City of Portland, Maine - Building or Use Permit Application
 389 Congress Street, 04101 Tel: (207) 874-8703, Fax: (207) 874-8716

| Permit No: 06-0788 | Issue Date: | CBL: 062 C011001 |

| Past Use: Two Family | Proposed Use: Two Family - Amend permit # 060186 add a a 5' x 15' deck | Permit Fee: \$30.00 | Cost of Work: \$30.00 | CEO District: 2 |

65 Thomas St.  
Back Porch

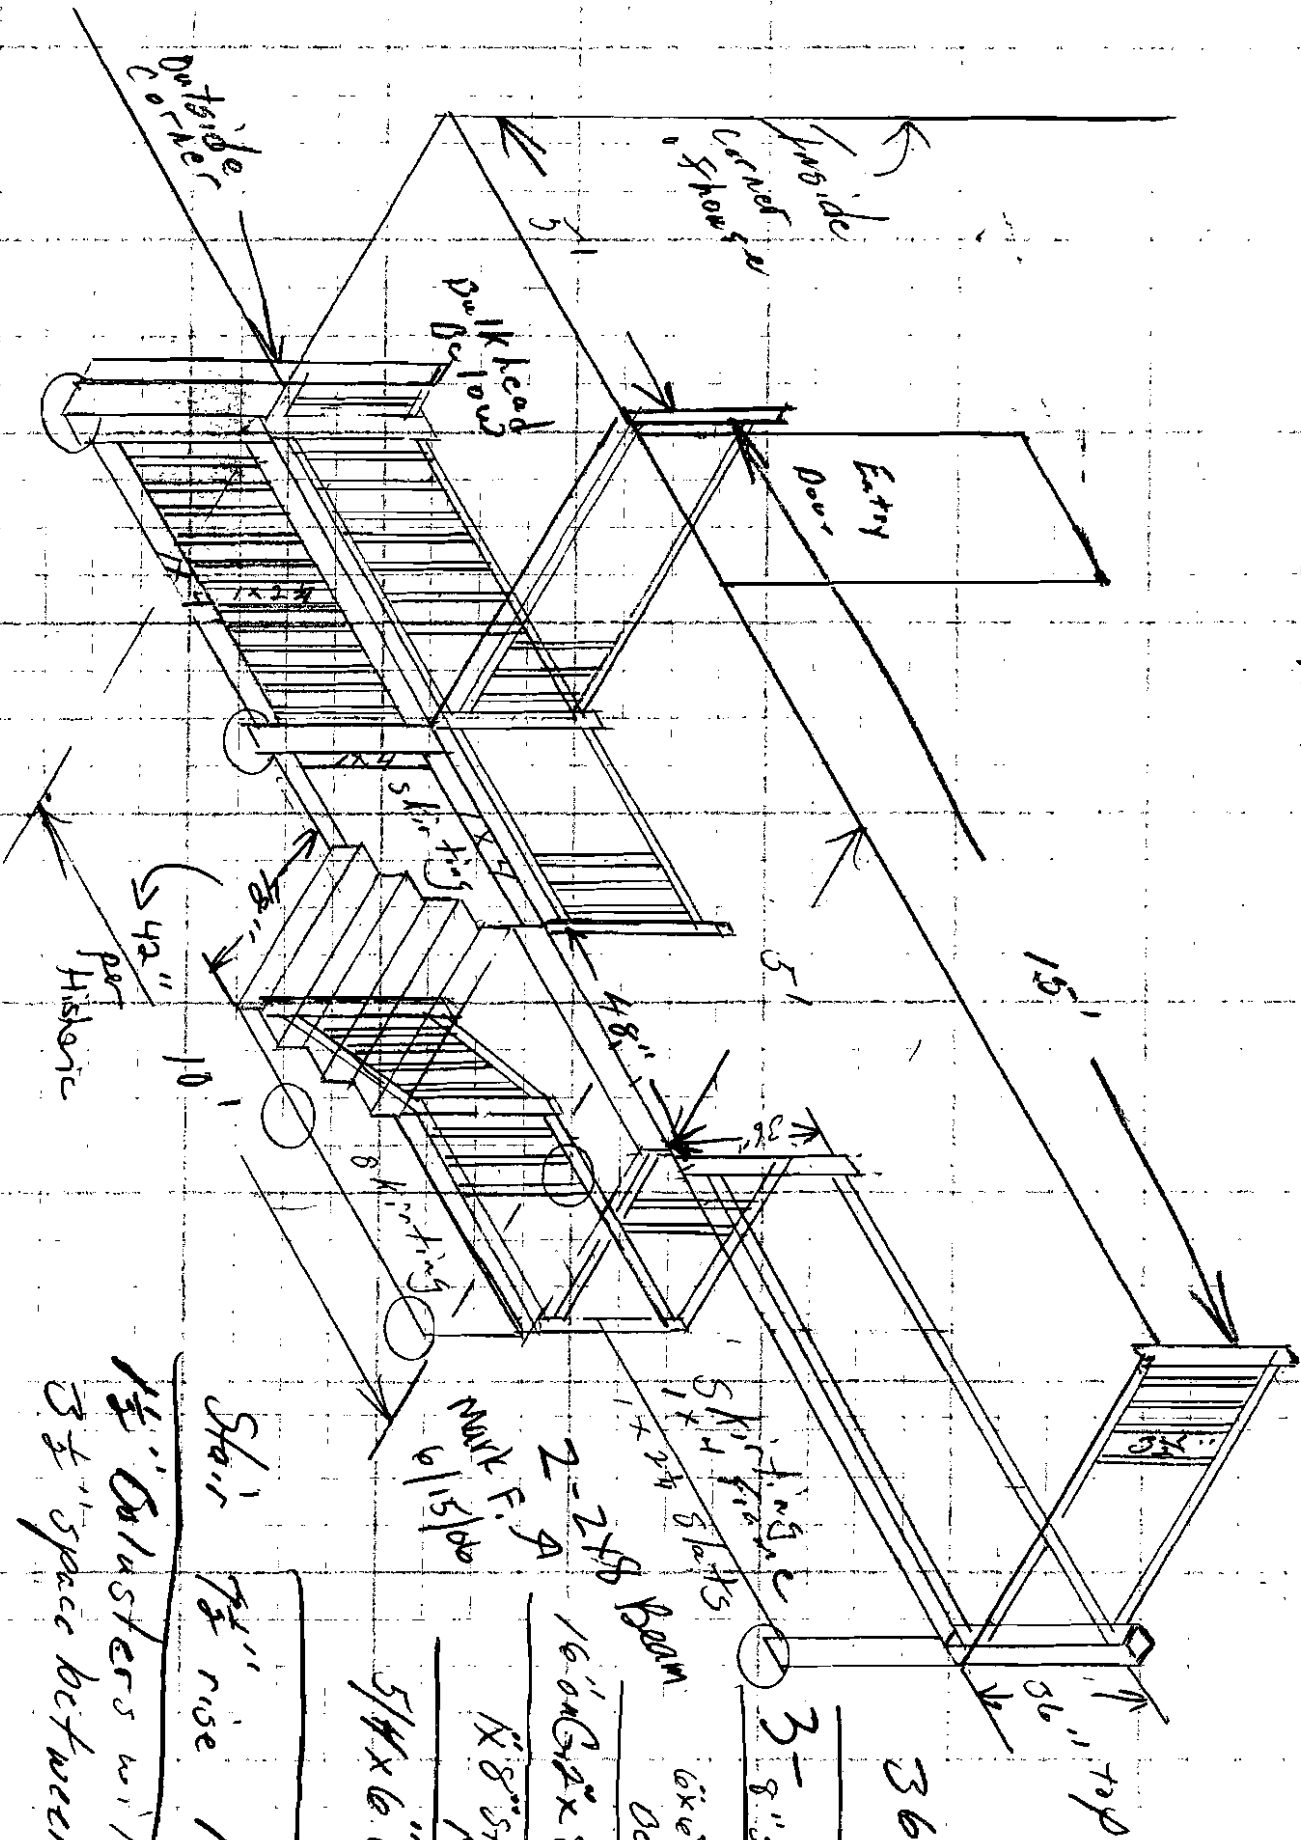
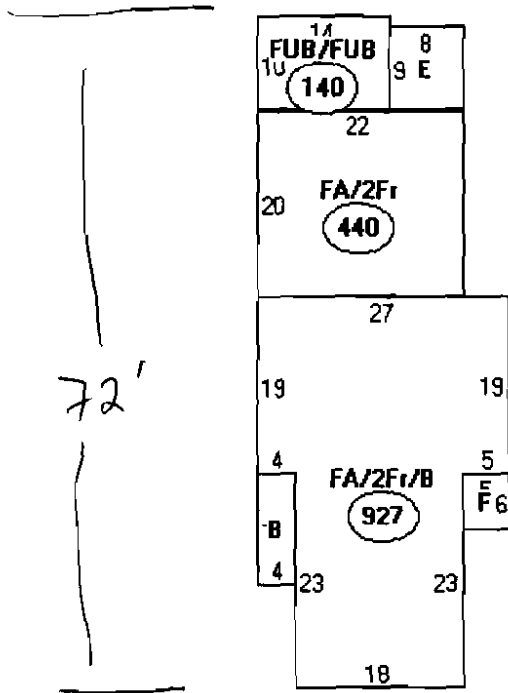
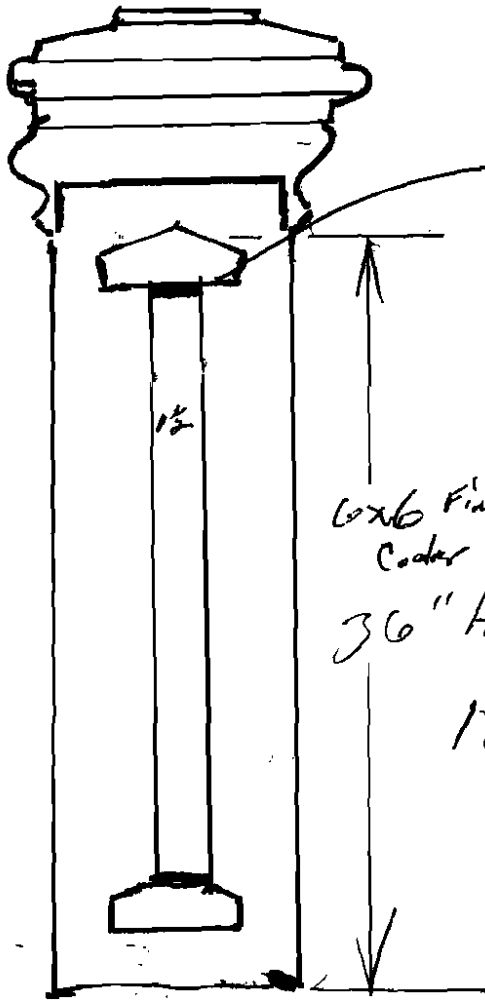
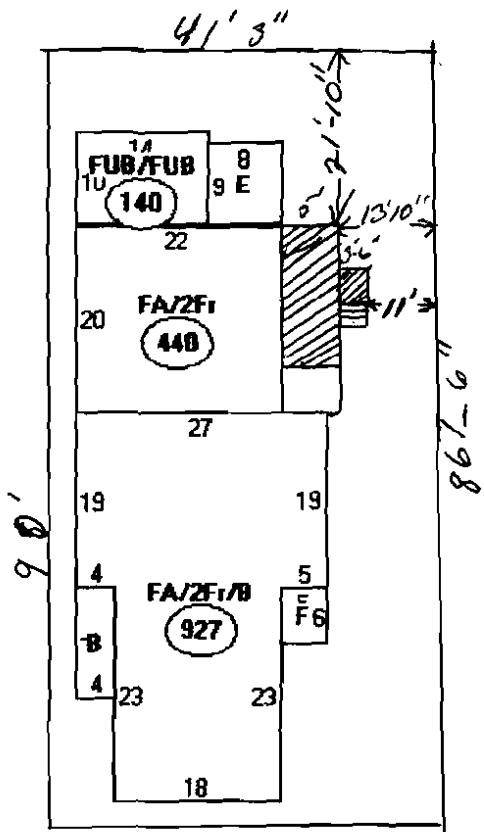
Dept: Historical **Status:** Approved with Conditions **Reviewer:** Scott Hanson **Approval Date:** 06/14/2006
Note: **Ok to Issue:**
1) The width of the stairs from the deck may not exceed 42".

06/13/2006-amachado: Left message for Mark Fuller. Need a plot plan showing the location of the building on the lot and the exact location of the proposed deck and the setbacks from the proposed deck including the stairs from the front, side and rear yards.
06/14/2006-amachado: Received plot plan.
06/14/2006-jmb: Left vm w/Mark F. For additional details - list w/permit
06/15/2006-jmb: Mark F. Called to verify details as noted on plans, ok to issue
